**Re: Noon Day
2500 Second St NW
Request Permanent C.O. - Accepted
Engineer's Stamp dated: 12-5-13 (H14D067)
Certification dated: 11-26-14**

Based on the Certification received 12/1/2014, the site is acceptable for release of Certificate of Occupancy by Hydrology.

**RE: Noon Day, 2500 2nd St
Grading and Drainage Plan
Engineers Stamp Date 12/05/13 (H14-D067)
Engineer's Certification Date 11/4/2014**

ENGINEER'S SEAL	NOONDAY	DRAWN BY WCHWJ
	GRADING AND DRAINAGE PLAN	DATE 12-05-13
		21344-LAYOUT-10-10-13
12-05-13	1806 CENTRAL AVENUE SUITE 201 ALBUQUERQUE, NM 87106 (505) 872-0999	SHEET #
DAVID SOULE P.E. #14522		JOB # 21344

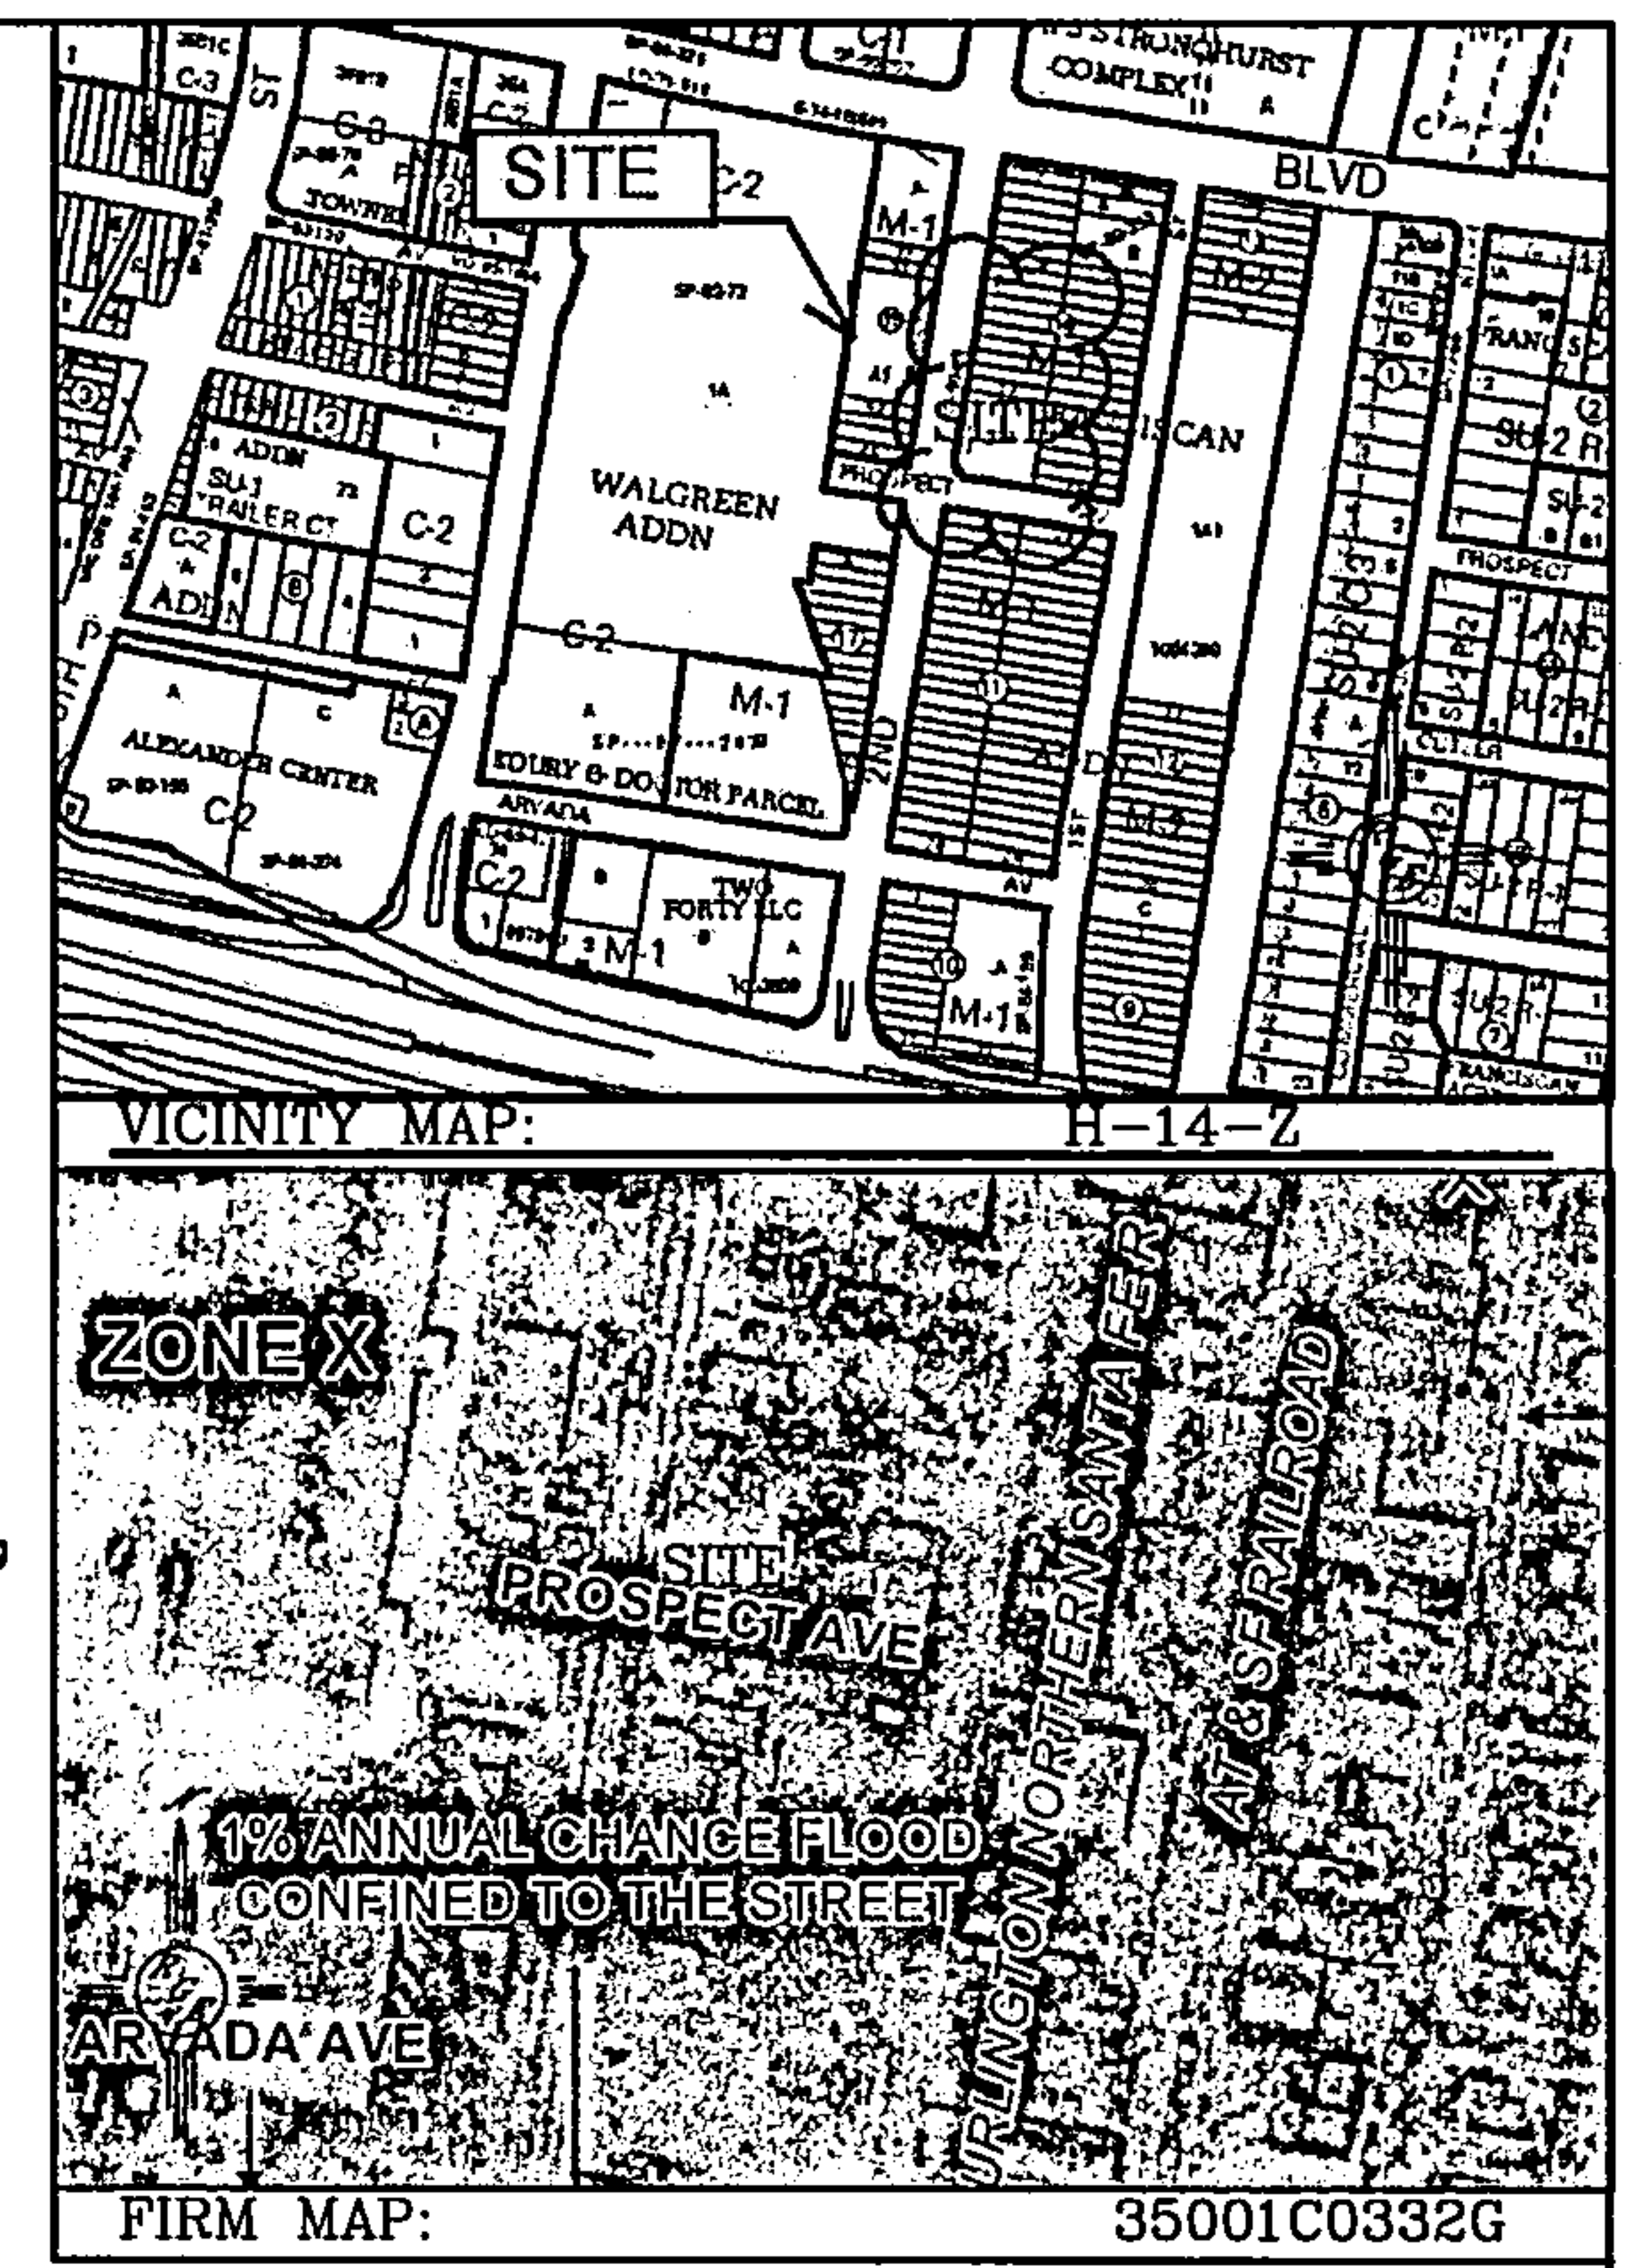
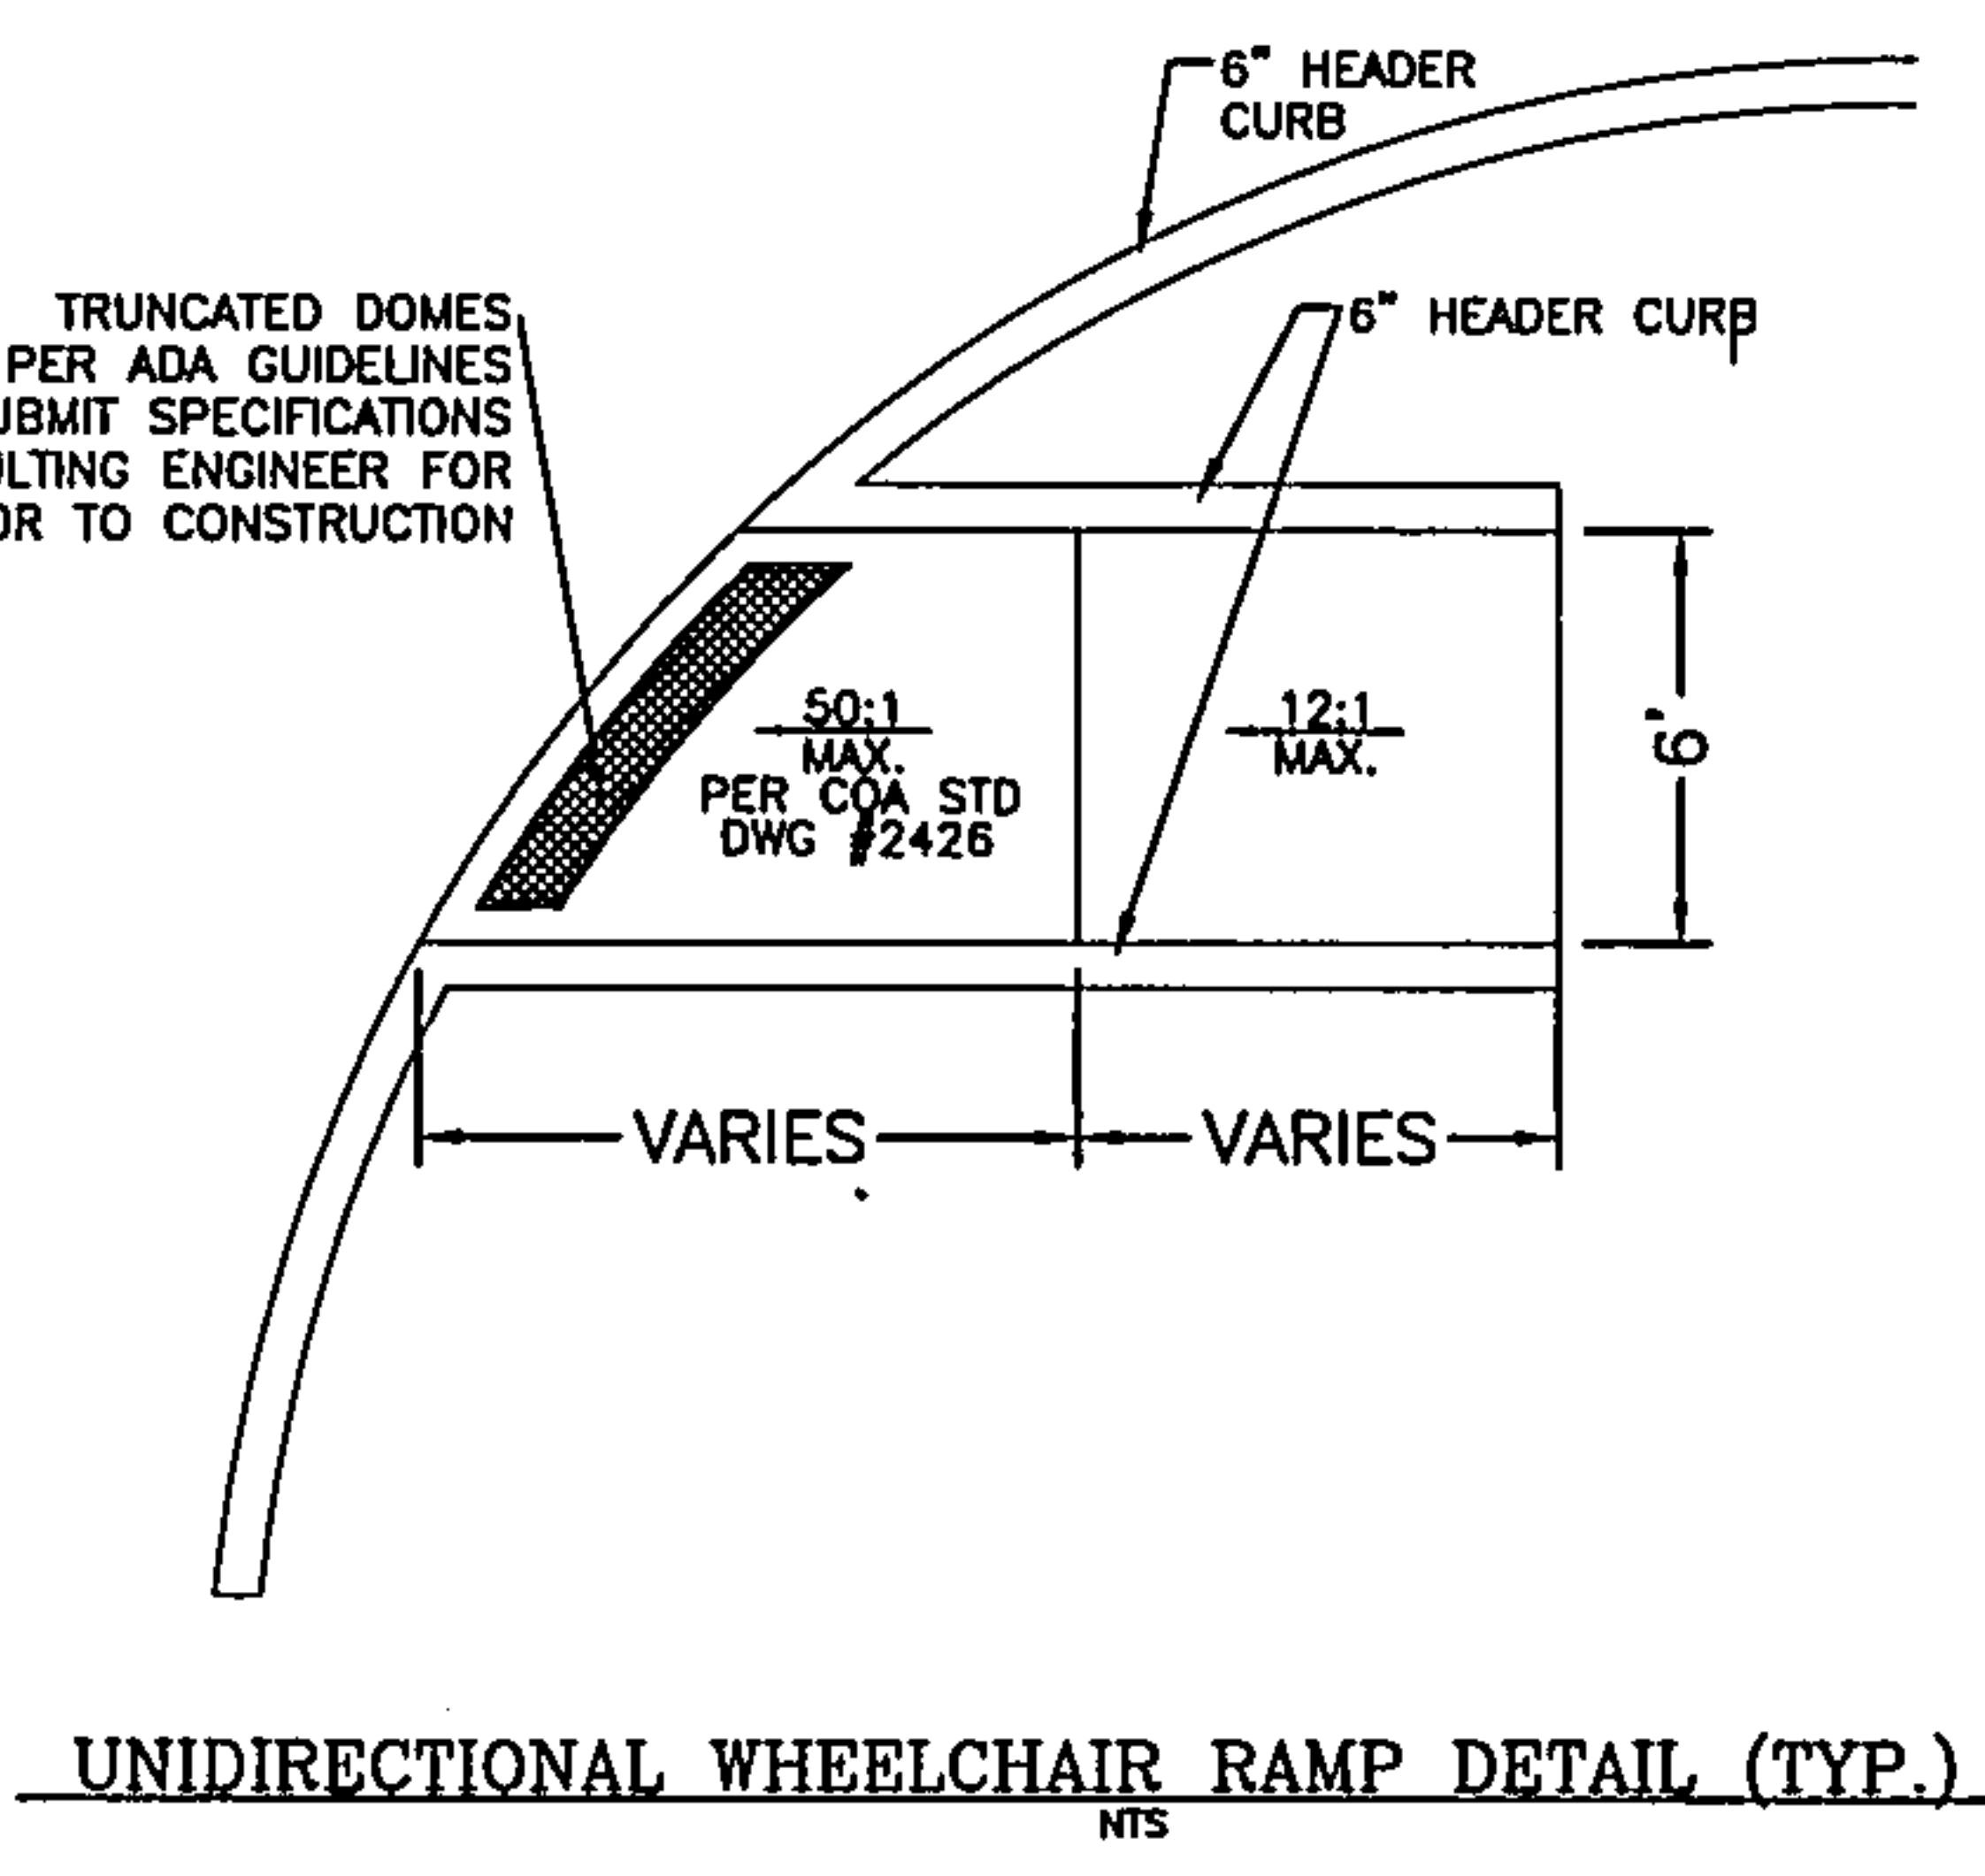
- provide calculations showing that the as-built width of the north sidewalk culverts is sufficient for drainage. It is built 17" wide but G&D calls for a 24" wide.
- On the north culvert, there is no expansion on both ends. Give room to have the 6" space for expansion on both ends. There is also no bar on street end of plate.
- The south culvert has a cracked center with missing concrete at face creating a tripping hazard. Recommendation is to remove south culvert, saw cut at cold joint ramp end.
- There is a cracked north side curb at cold joint through the back of curb, epoxy over bolts
